Your Ref: OWPC18935
Our Ref: WA/39/18/PL 19-04-2018
Please ask for:
Andrew Wood

Extension of existing dwelling to create 1 No. attached dwelling.
48 The Meadows Walberton

Thank you for your internet representation made on 20th June 2018 which has been recorded as **'an objection'** with the comments as follows:

Proposed Plans and Elevations

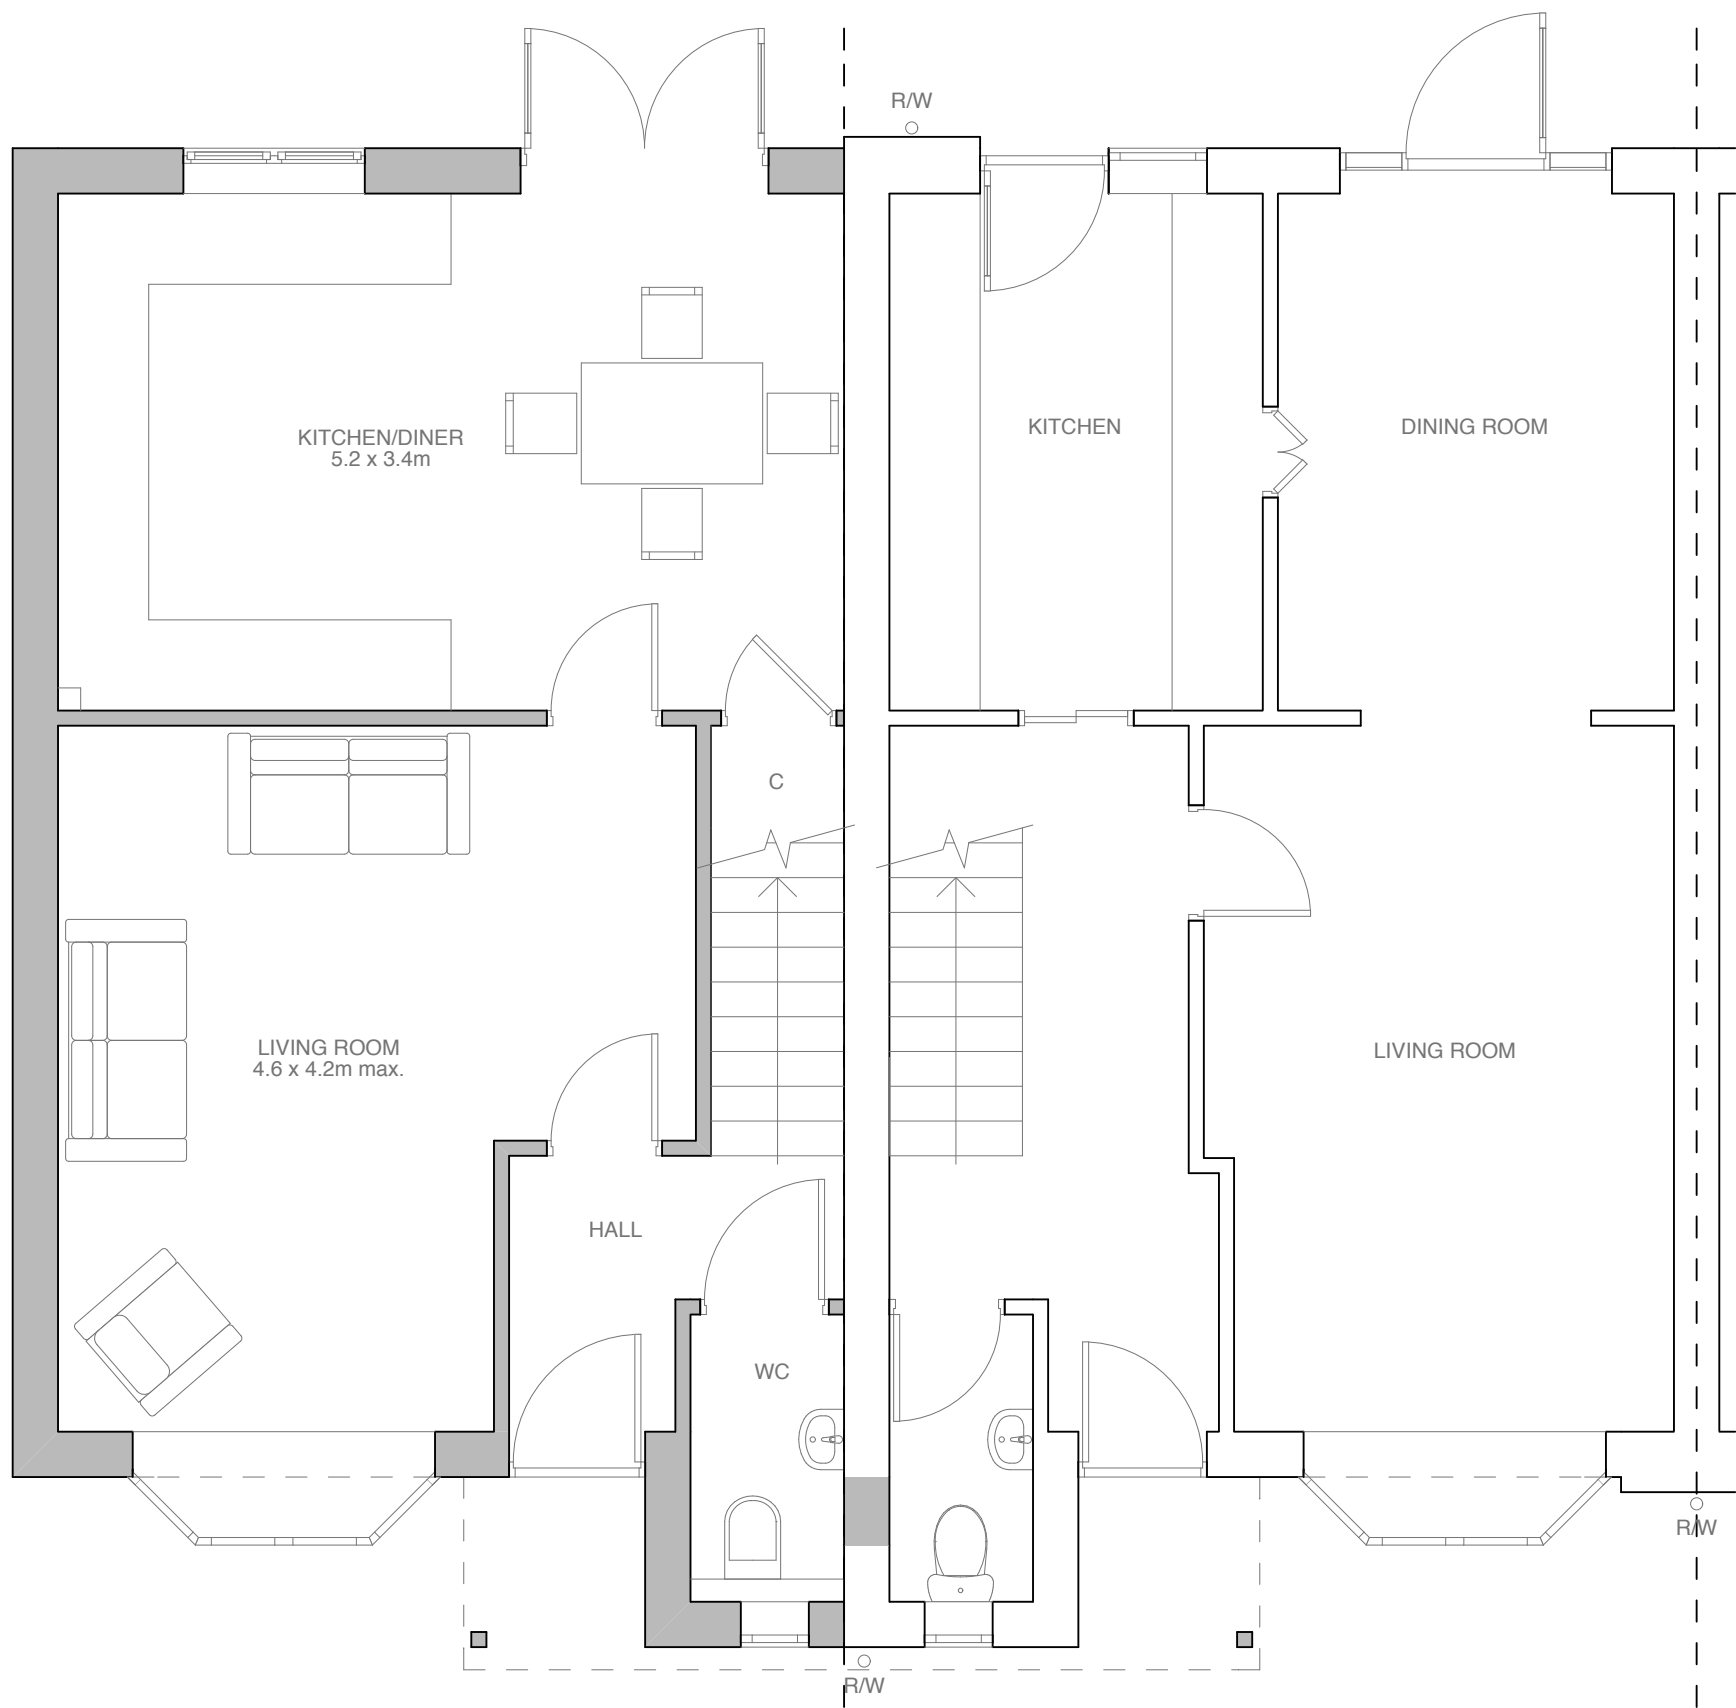
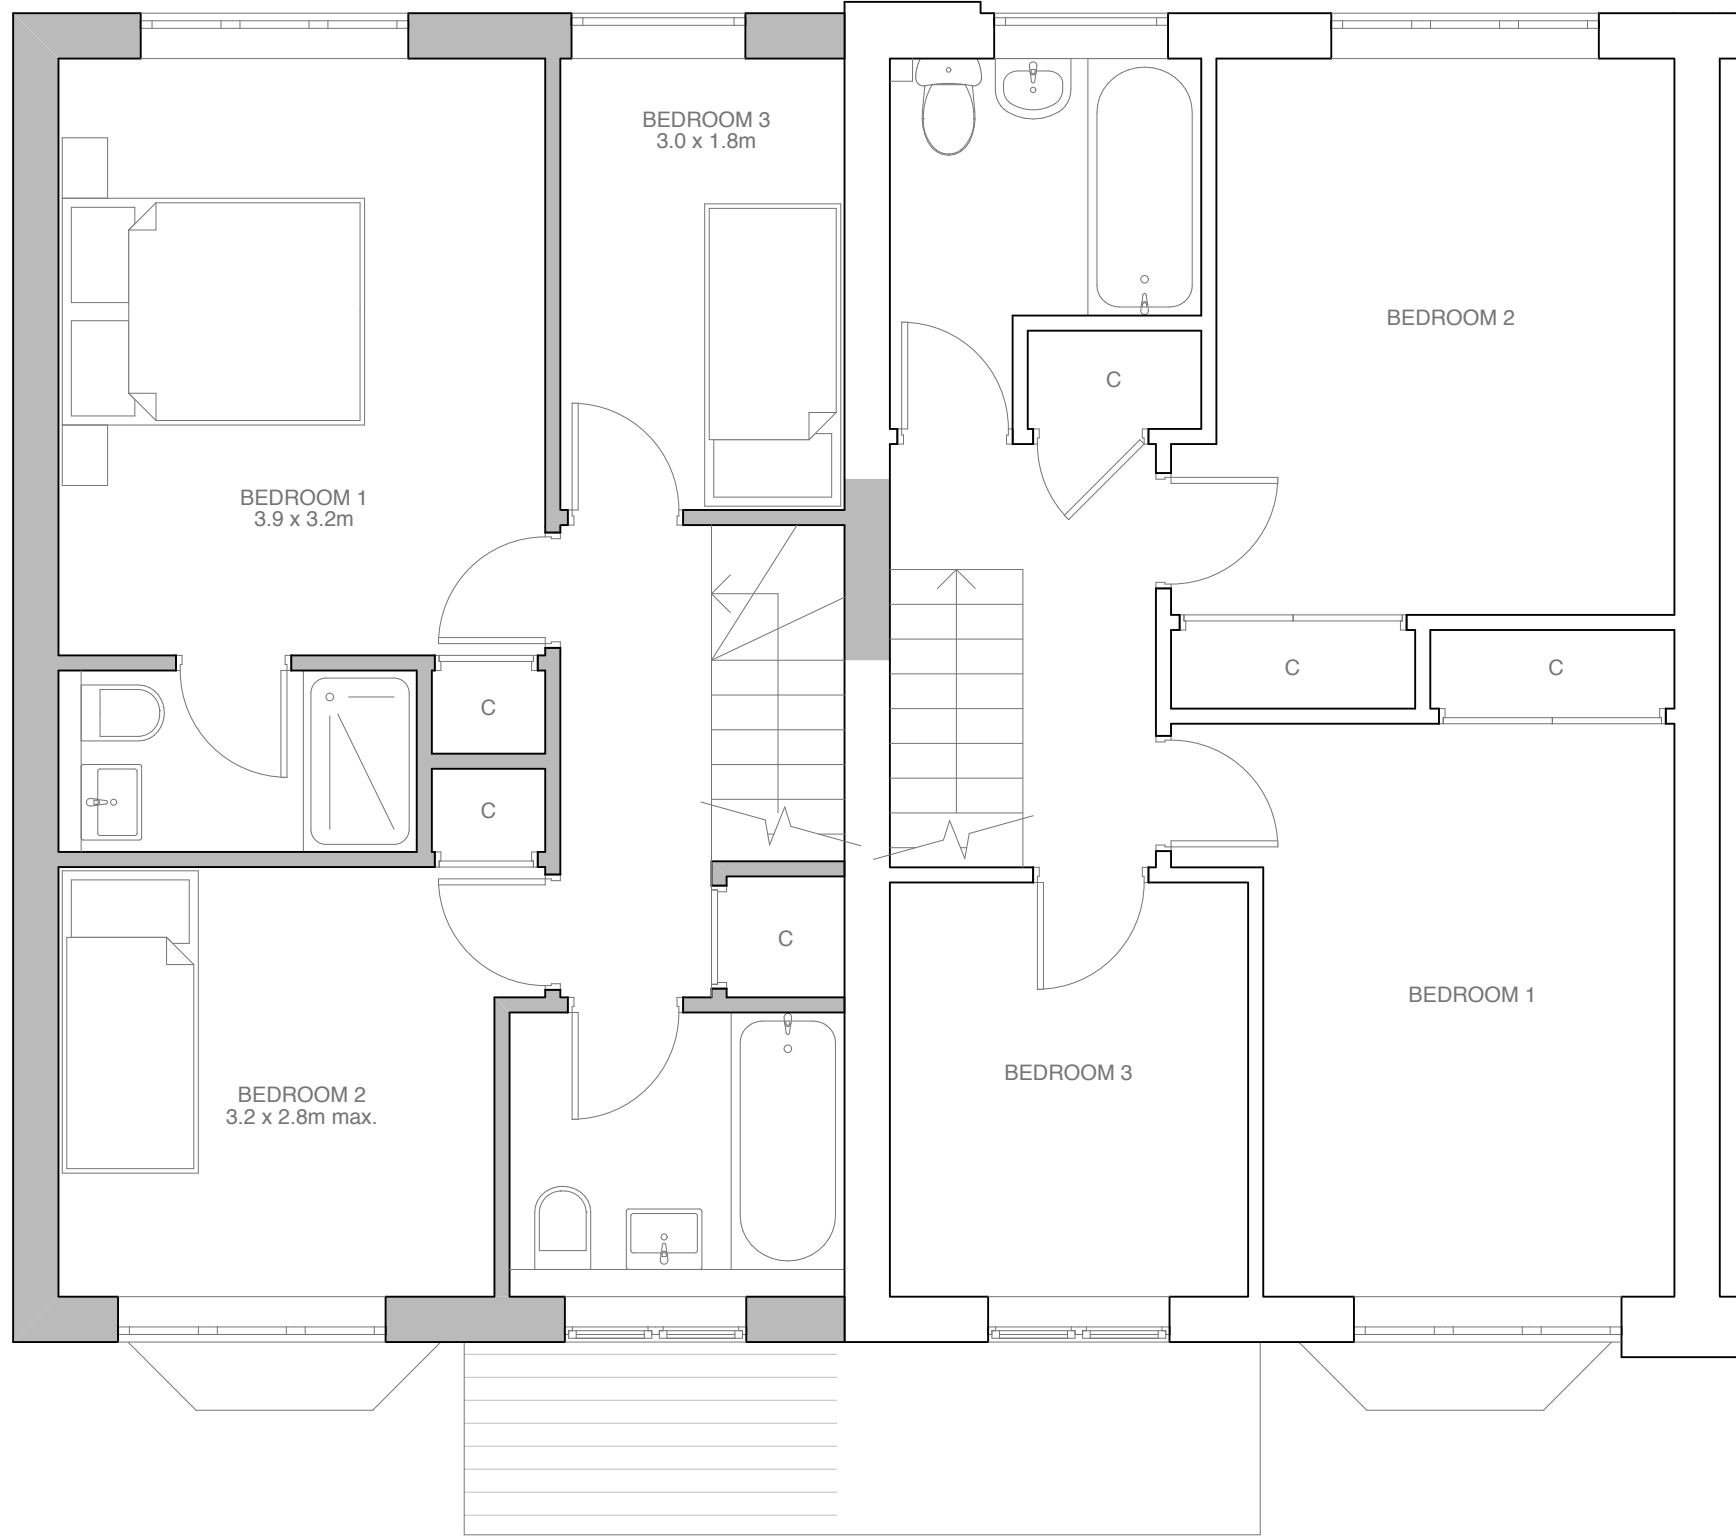
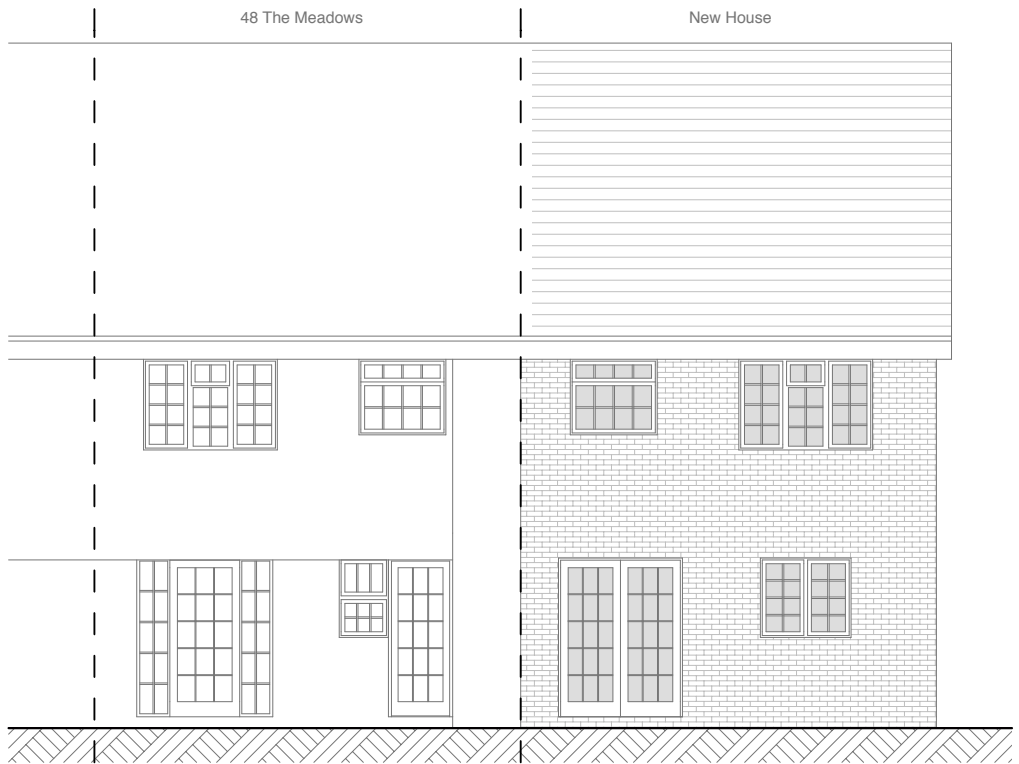
The proposed dwelling is only situated 4.6m back from the boundary/footpath. This clearly demonstrates that there is not enough space for 2 parking spaces in front of the proposed dwelling, especially as there is a bay window and porch proposed which also encroach into this space (The existing garden wall is set much further back from the terrace building line so the current parking spaces have enough depth). Therefore if this application is approved as currently shown, the occupiers of the new dwelling will not be parking their 2 cars off road, but on the road!

All houses in The Meadows currently have a soft landscaped front garden. The new dwelling proposes a completely hard landscaped (albeit very short) hard standing for parking which is out of character with the rest of the terrace and the other houses.

The proposed dwelling will also need to increase considerably in size as it currently does not meet the minimum space requirements set out in the Nationally Described Space Standard for a 3 bedroom/4 person dwelling, as required by the Arun Local Plan.

1:500 Block Plan

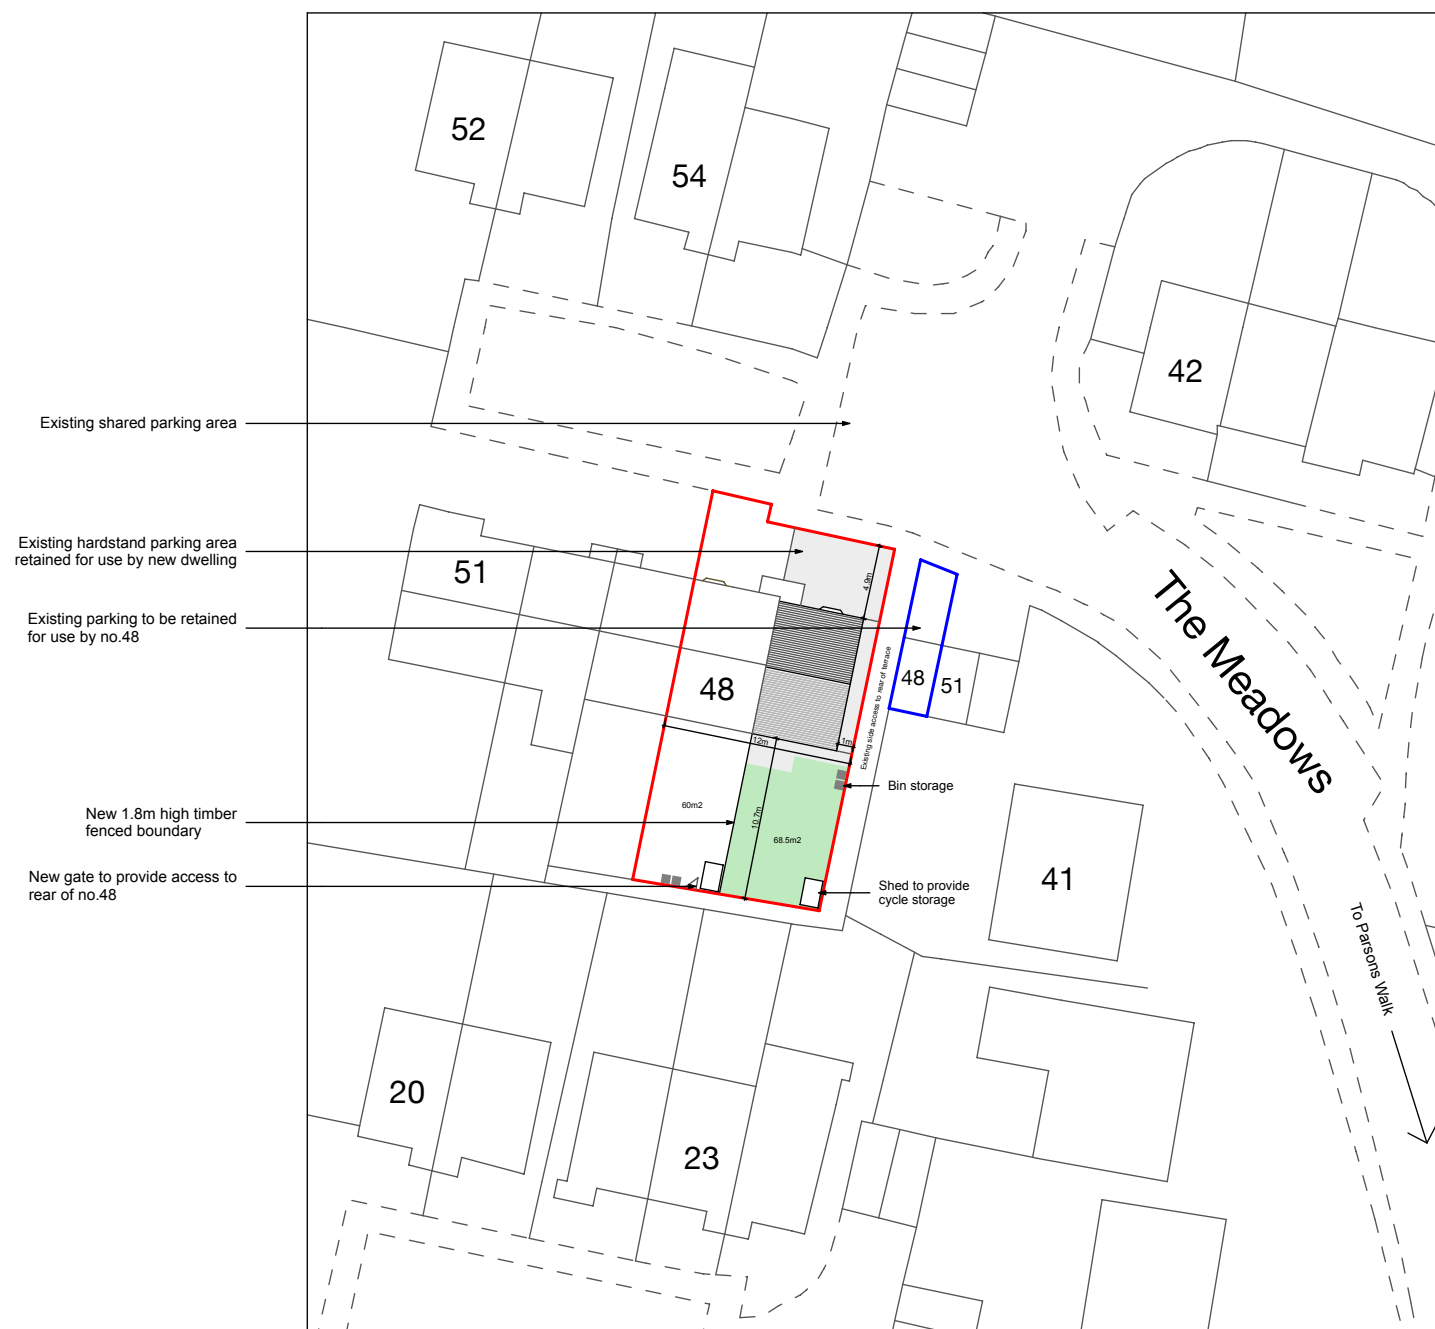
If the proposed dwelling is moved back, so 2 off road parking spaces can be achieved, the 6 on road parking spaces would then be reduced to 4, so the new dwelling can access both spaces freely. Couple this with the loss of parking for No.48 (proposed 1 parking space) and we now have 4 on road parking spaces for 9 houses to share! A new dwelling would also generate more visitors requiring parking too!
